Application No: R/157/20/HH
Site Address: 70 Sea Avenue Rustington BN16 2DJ
Description of works: Hipped roof to gable end to west elevation. Roof dormer to north elevation. Pitched roof to replace flat roof to existing dormer to east elevation and external and internal alterations.

Thank you for your internet representation made on 18th September 2020 which has been recorded as no objection with the comments as follows:

Proposed Elevations 1/100

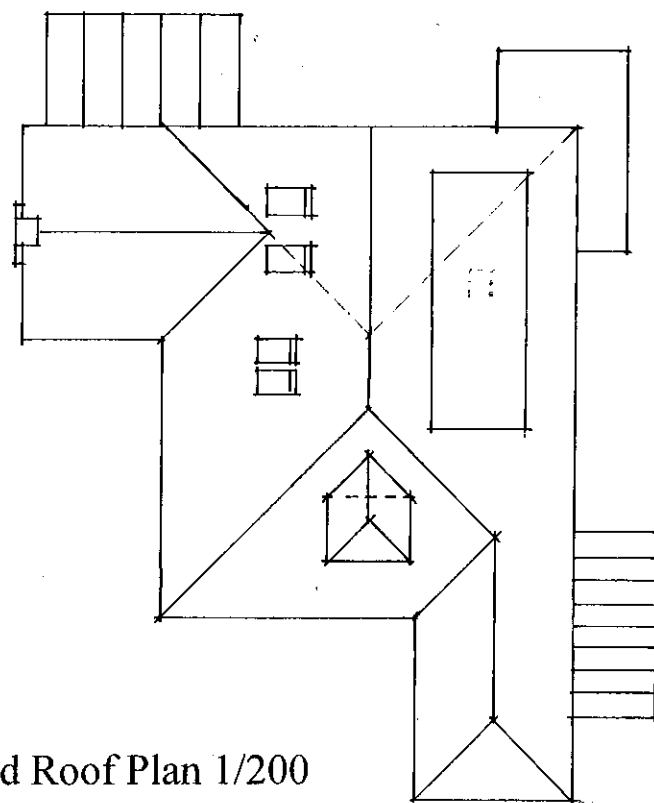
My Council has noted the above application and wishes to raise no objection to it, subject to the dormer windows on the north elevation, overlooking No. 68 Sea Avenue, having obscured glazing.
